From: Ancient Monuments Society [ancientmonumentsociety@btconnect.com]
Sent: 24 August 2012 18:34
To: Jane Tucker
Subject: Re: Consultation on planning application 3/2012/0709 St Johns Church, Shire Lane, Hurst Green
 Thankyou for your consultation.

Please can we have your comments on the above planning application? It is for the creation of accessible and sustainable composting toilet facility externally to the rear (North) of the church. Adaptation of lower section of existing window to form level access to accessible toilet from inside the church with clear separation between door head and window sill provided by the natural stone infil. Associated creation of level approach to the perimeter of the church by improvements made to existing North and West facing paths. I have attached the formal consultation but there are too many plans and documents with the application to attach to an email, so here is a link to view them on our website <http://www.ribblevalley.gov.uk/planningApplication?appNumber=3%2F2012%2F0709&submit=Go>

East Elevation.

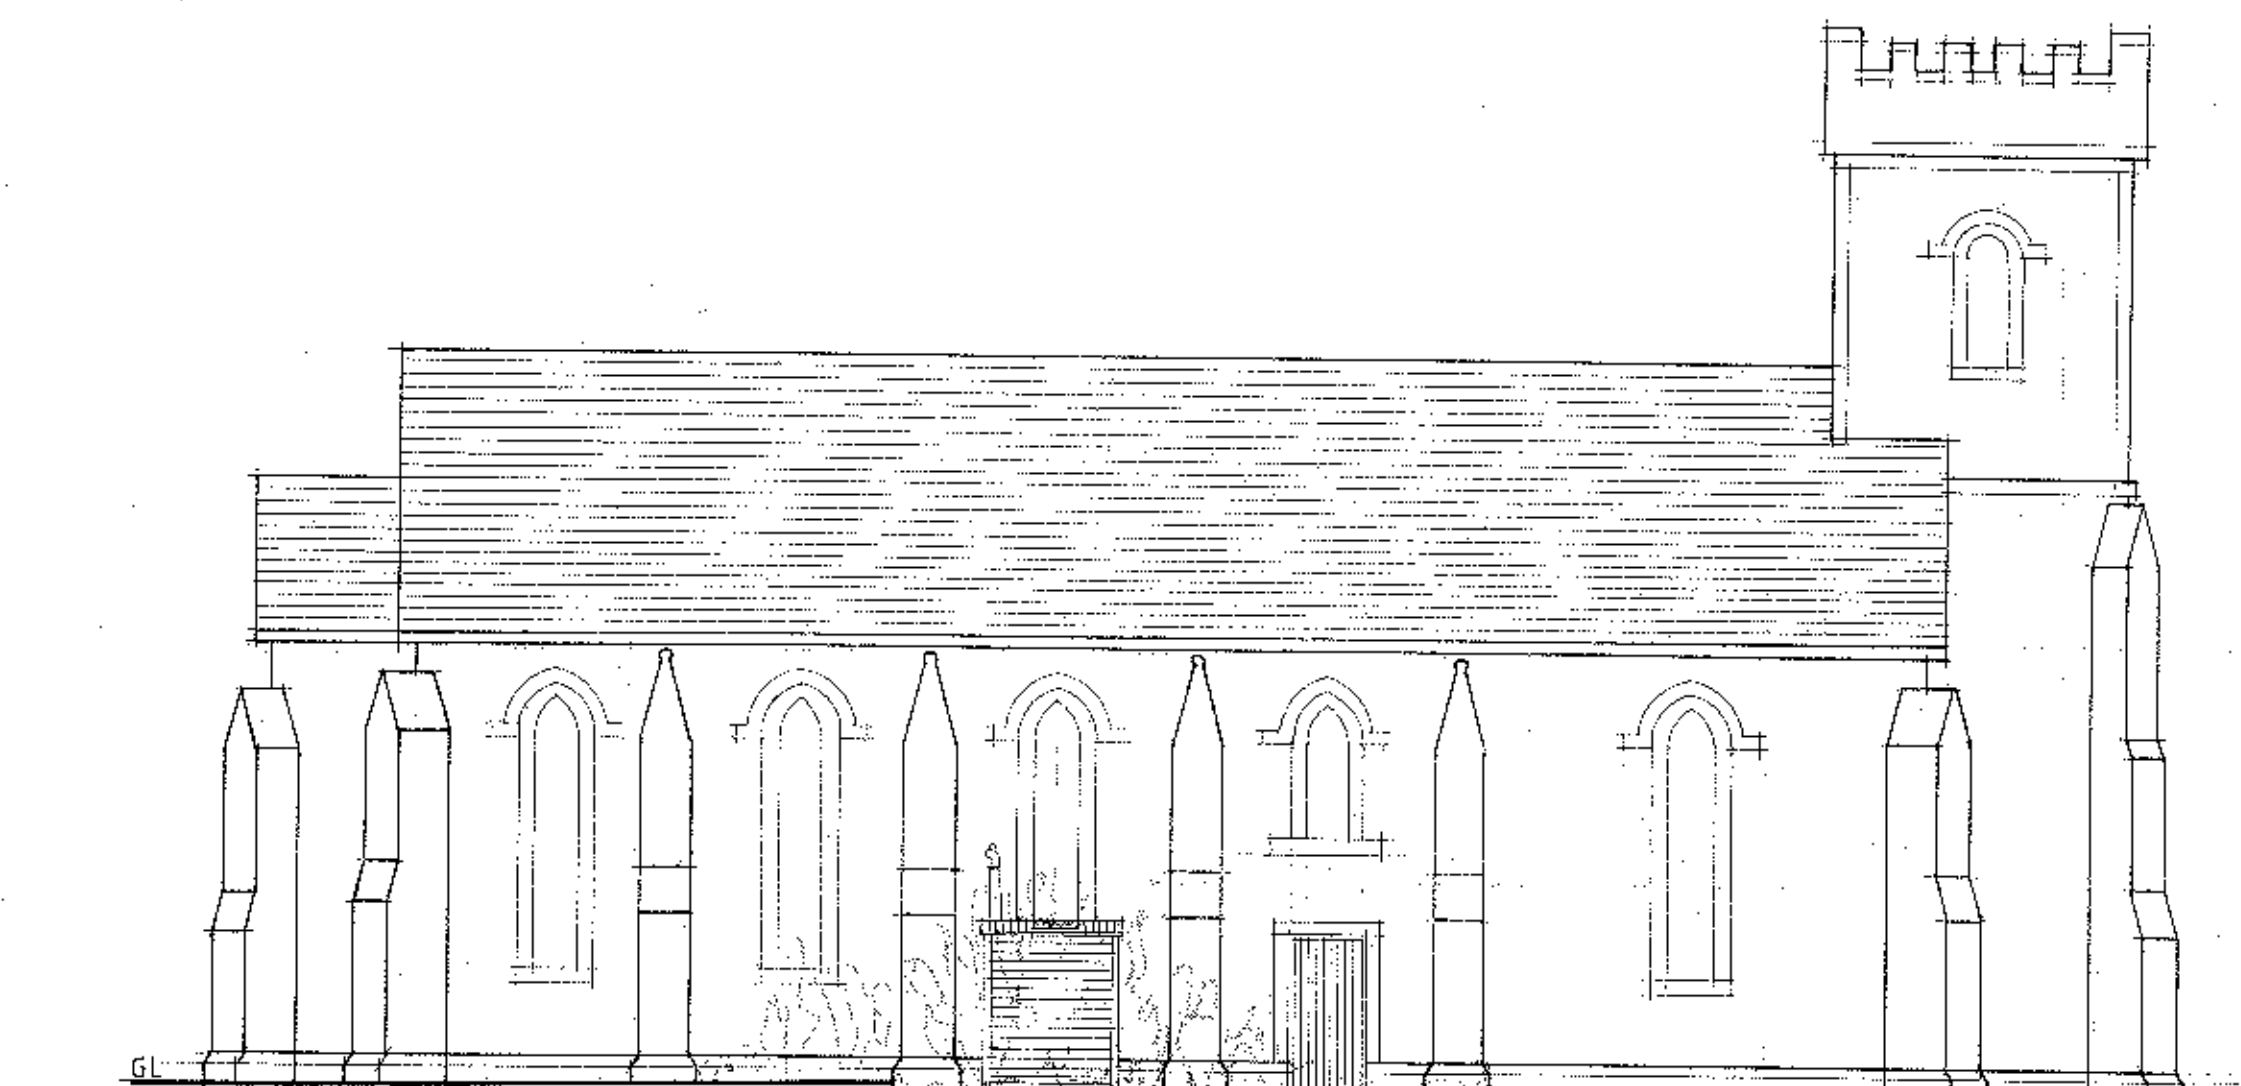
As the new facility is diminutive compared with the dominance of the church, the adverse affect on setting is clear but minimal. The analogy perhaps is with the many lawn mower sheds in a country churchyard.

Even so, it would surely be less intrusive and more user-friendly if the loo were provided discreetly within the interior. It is true that the openness of the interior and the lack of the sort of spaces which have been used on similar occasions - a north porch, a vestry or a tower base (already taken by the kitchen) - creates problems but loos disguised, for example, as vestment cupboards at the west end do work in visual terms.
